CITY OF ALBUQUERQUE

Hydrology Section Planning Department
Brennon Williams, Acting Director

July 31, 2019

RE: **Mister Car Wash – 201 98th St NW**
ESC Plan Engineers Stamp Date: 7/23/2019 K08E004

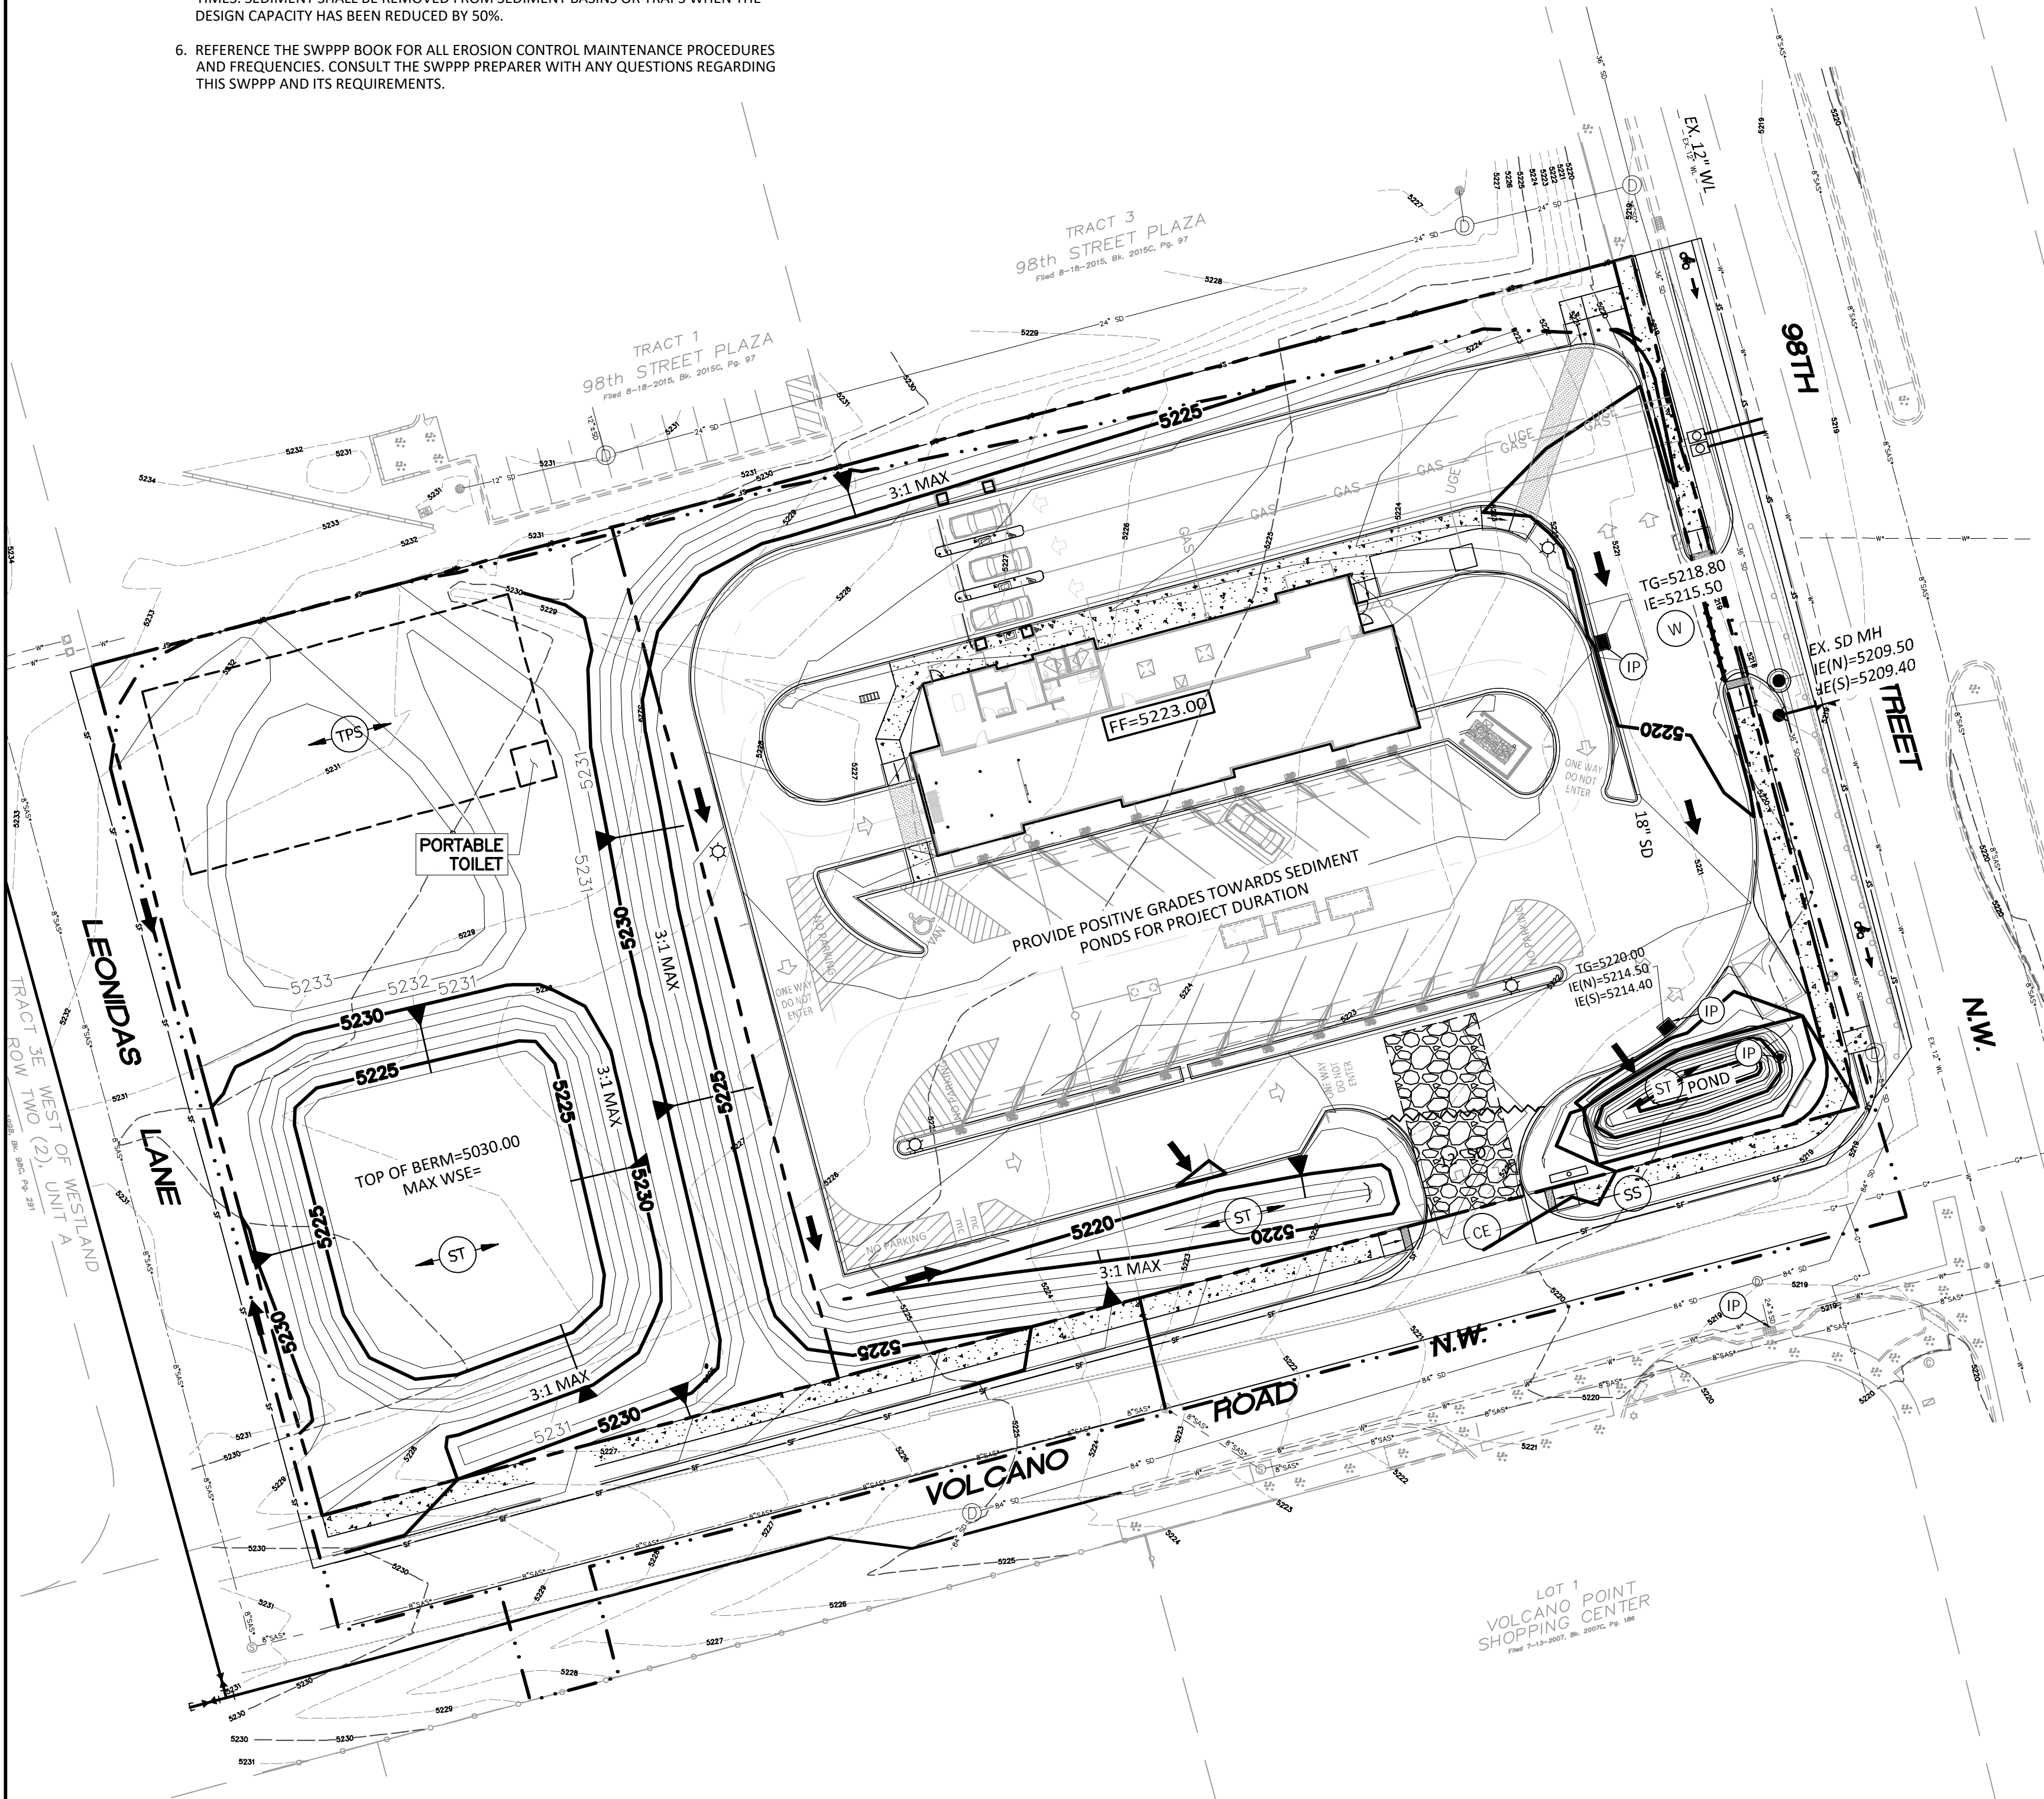
1. Clearly show the limits of disturbance including the area to be disturbed by the Work Order.
2. Clearly add a perimeter control around the low side of the project like Silt Fence
3. Clearly add inlet protection at the pond outlets and inlets in the public ROW.
